# TEXT\_ISH16\_EA1N&2\_Session4\_26052021

Hello, and welcome back, everyone. Just before we begin, Can I check with the case team that you can hear me and that the recordings, live streams and live captions have started. I can see and hear you. And superlines it. Thank you very much. Nice. Thanks, Liam. Okay, and we were up to item C of this part of the agenda, which deals with the outline operational drainage management plan.

Appendix 3: Infiltration Basin Figures

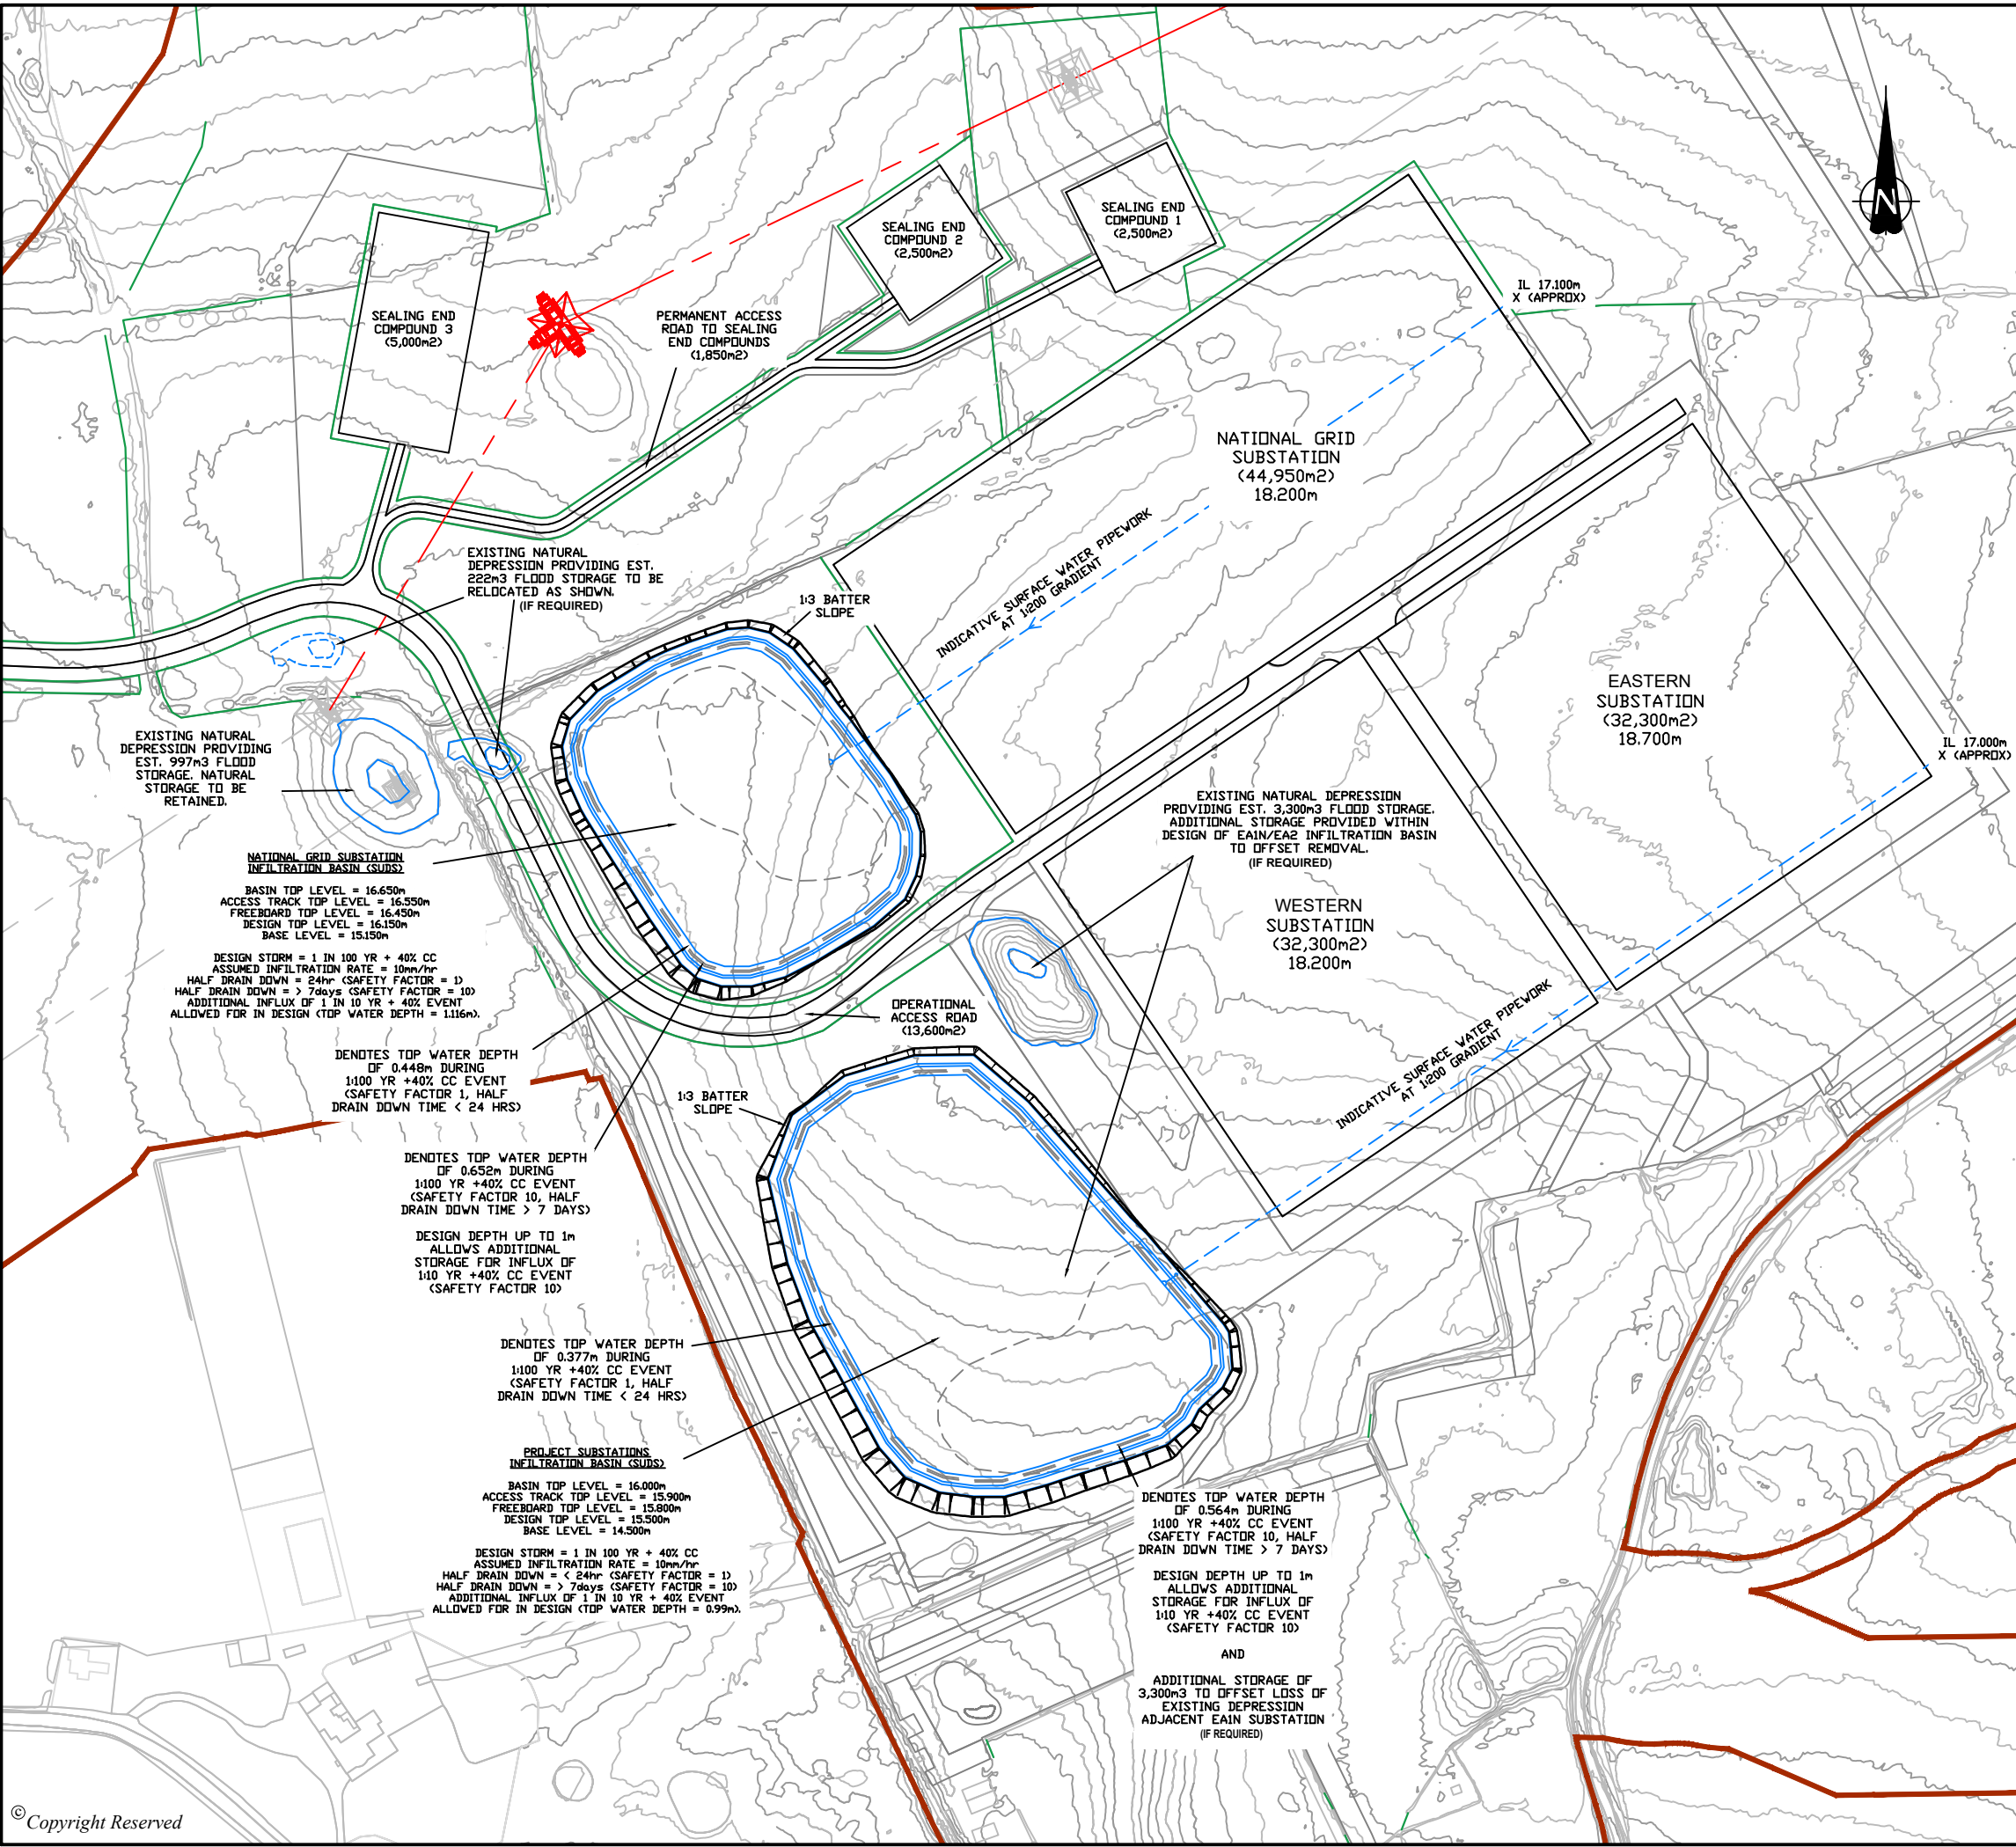
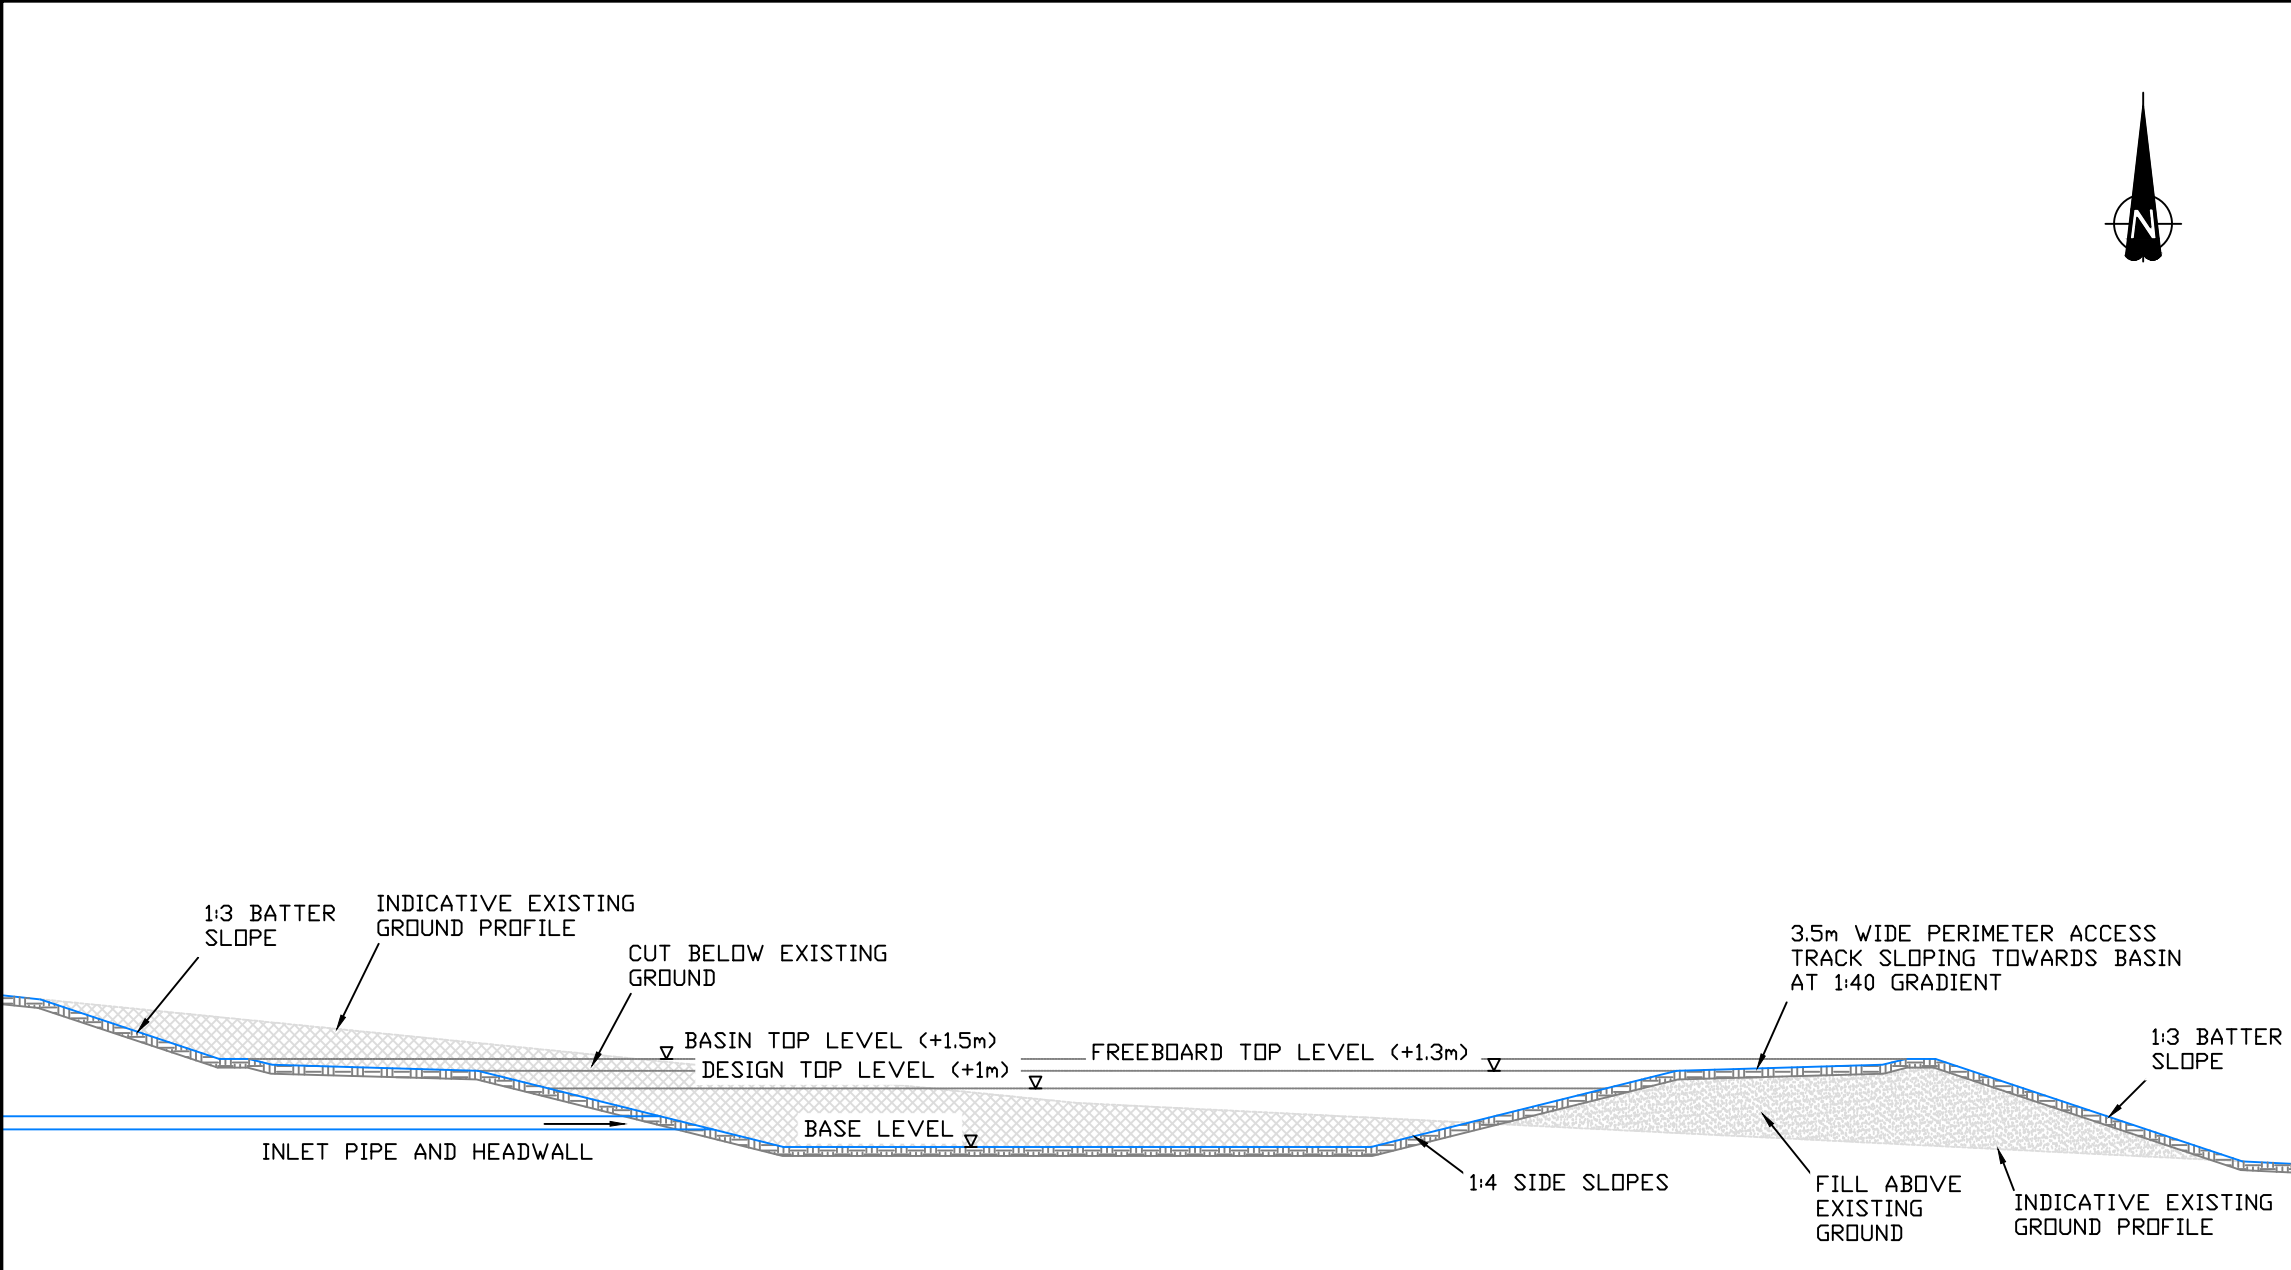
Okay. Now, I know there was some comments made by Suffolk County Council in response to the depths of the basins making comments that the depth of the basins in appendix four six and eight of the outline operational drainage management plan showed the difference between think 1.5 and two for

infiltration and hybrid in terms of the depths. So, the new lines on drawing a water the depths of those of those storage basins

Okay, so the size of the basins that you're showing on drawing a the depth of those basins do they comply with this area? Since manual

the design depth for for the ponds on a safety factor of 10 was one metre deep there are further allowance for a 300 millimetre freeboard and then there was further allowance for 200 mil I believe in place in the field further freeboard which I would think then goes for the allowance of the overflow. So, if the system is to overflow controllably the freeboard would have to be slightly higher. So, then there could be controlled discharge

for the water level design yes design water levels one metre max. Okay, and what about the the overall depth? overall depth was 1.5 metres deep with the freeboard
